Ferring Conservation Group
Stephen Abbott

Application No: FG/155/25/PL

Site Address: Land between 11A The Grove and 30 Brook Lane Ferring BN12 5HZ

Description of works: Erection of 1 No 1-bedroom self build house with associated parking & private outdoor amenity space. This application is in CIL Zone 4 and is CIL Liable as a new dwelling.

A :: Block Plan
01 scale: 1:200

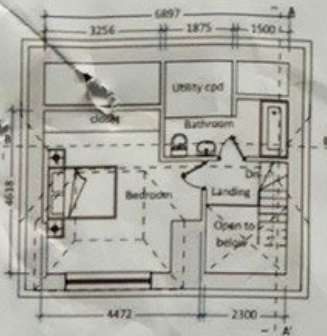
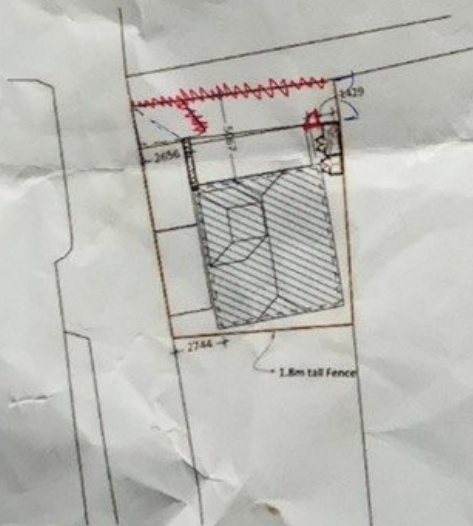
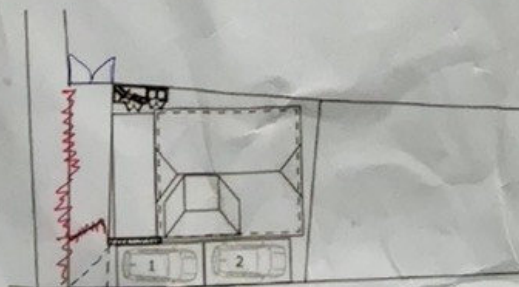
Due to the limited size of the plot, the proposed parking spaces do not meet the minimum requirements as set out in the current Manual for Streets, as confirmed by the WSCC - Highways Authority. The proposed spaces are likely to prove insufficient for vehicles to manoeuvre without difficulty. The resulting negative amenity impacts of the proposed smaller, non-compliant spaces potentially adding to on-street parking in this narrow private street with no street lighting or pedestrian footway.

The proposal presents an overshadowing impact on the neighbouring property's rear garden and outlook as it is sited so close to the eastern boundary. Sinking the dwelling and garden patio into the ground is not an innovative solution to the massing of the property but a desperate attempt to fit a dwelling onto an unsuitably small and irregular plot. There is insufficient evaluation of the impact of reducing the ground level in terms of flood risk or undermining and destabilising the adjacent access drive on the northern boundary or how these issues will be addressed.
